Re: Comment Response to City of Portland Peer Review Engineer
Harborview Development, LLC – 121 York Street

On behalf of the project team Acorn Engineering, Inc. is pleased to respond to the comments provided by the City Peer Review Engineer dated June 23rd, 2011 by David Senus, P.E. and Ashley Auger, E.I.T. of Woodard & Curran.

1 RECONSTRUCTED BRICK DRIVEWAY APRON LAYOUT  
NOT TO SCALE  
L3.0

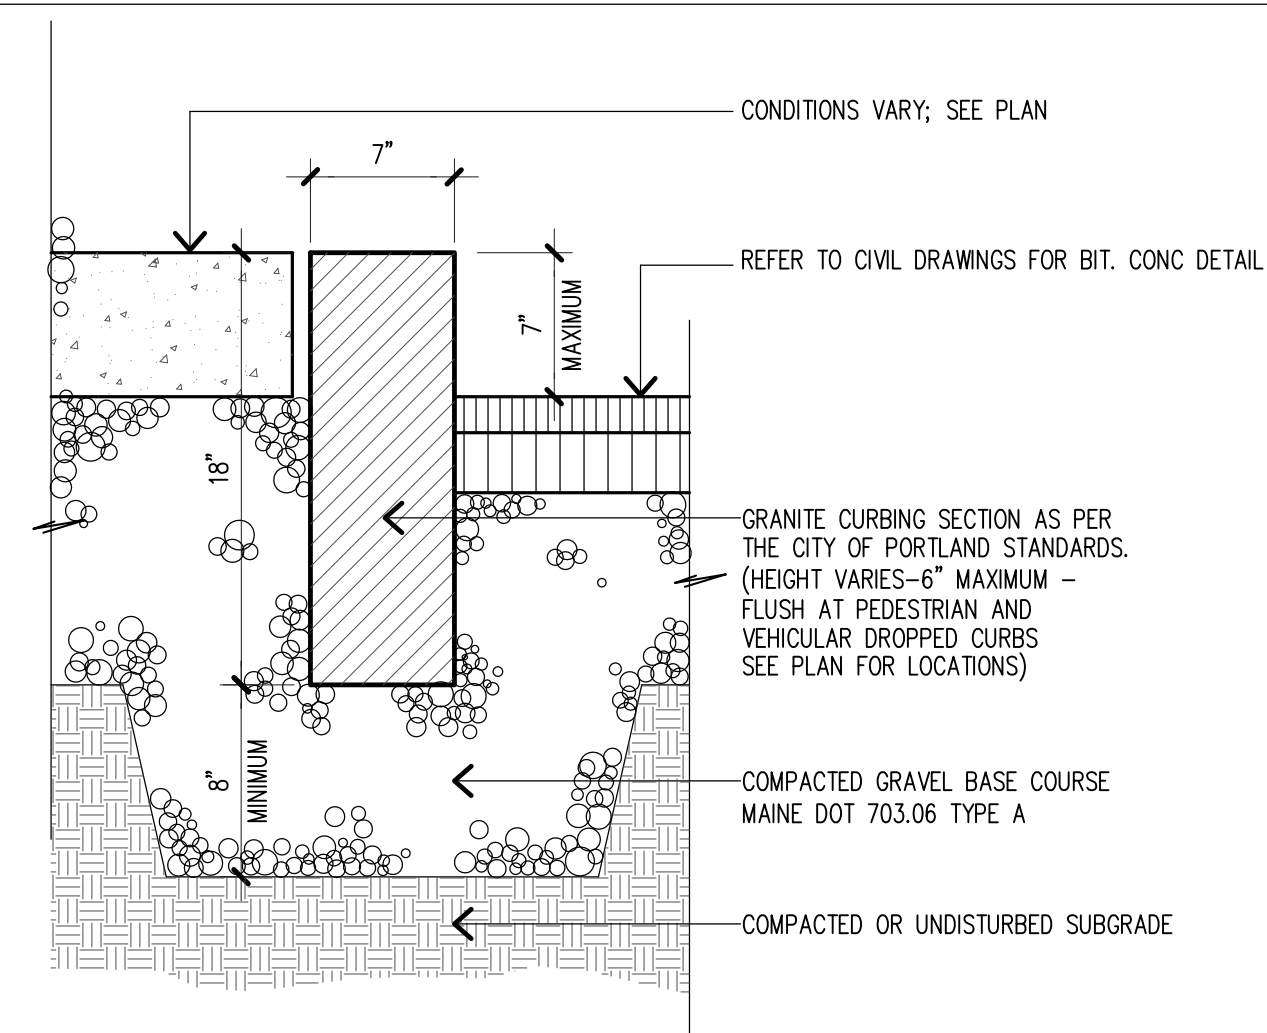
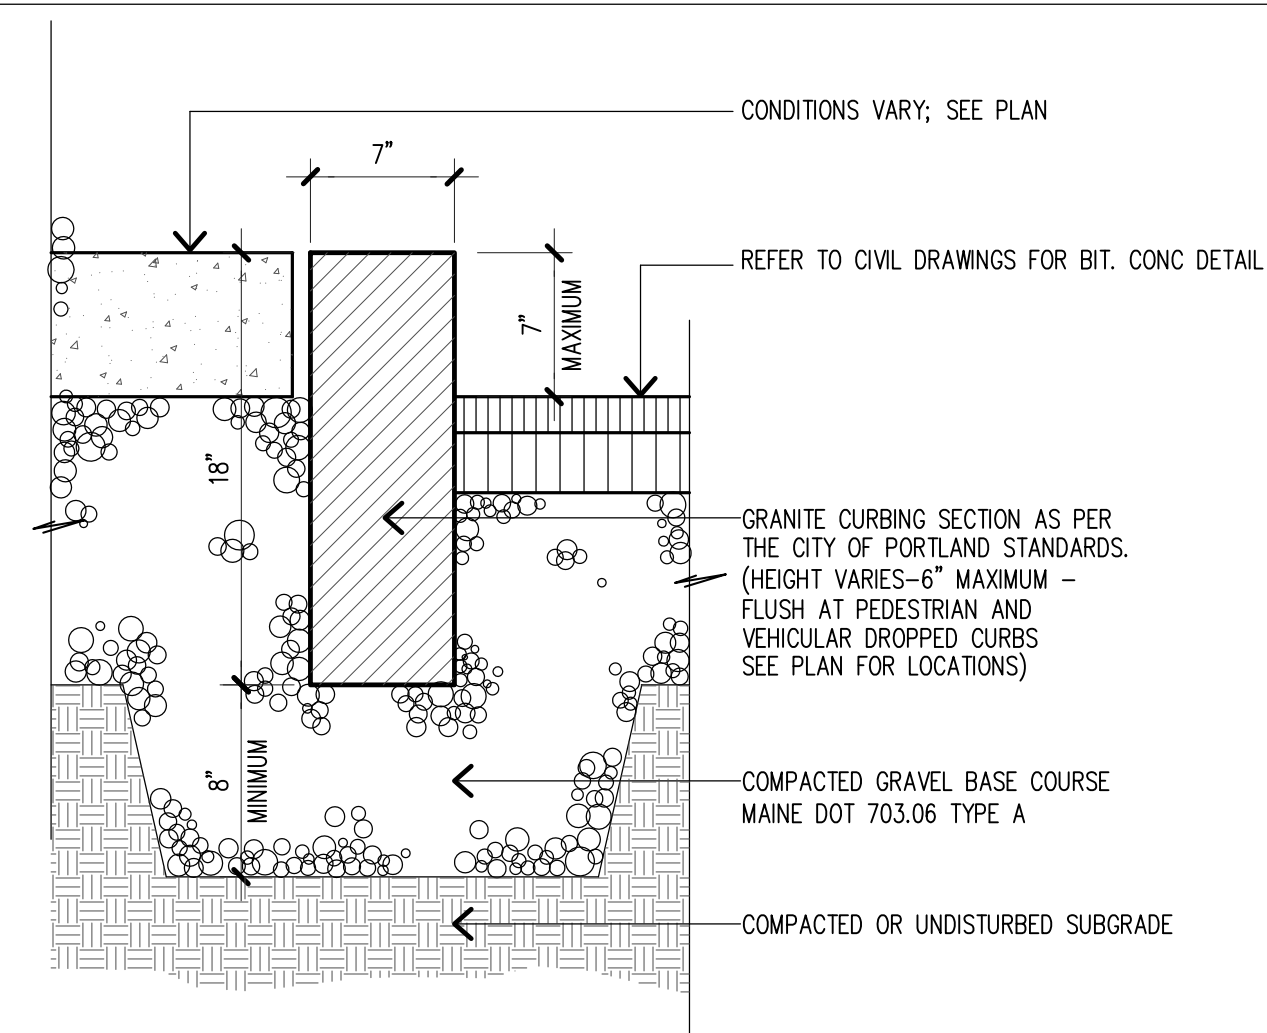
3. *The updated plans still do not provide clarity to the location and type of proposed curbing and sidewalks within the site.*

Response: Please refer to Soren Deniord Design Studio's - Site Plan for the location of granite curbing. To facilitate your review the curbing linetype was darkened and depicted within the symbols legend. Refer to Soren Deniord Design Studio's – Landscape Details for curbing within the reconstructed brick driveway apron.
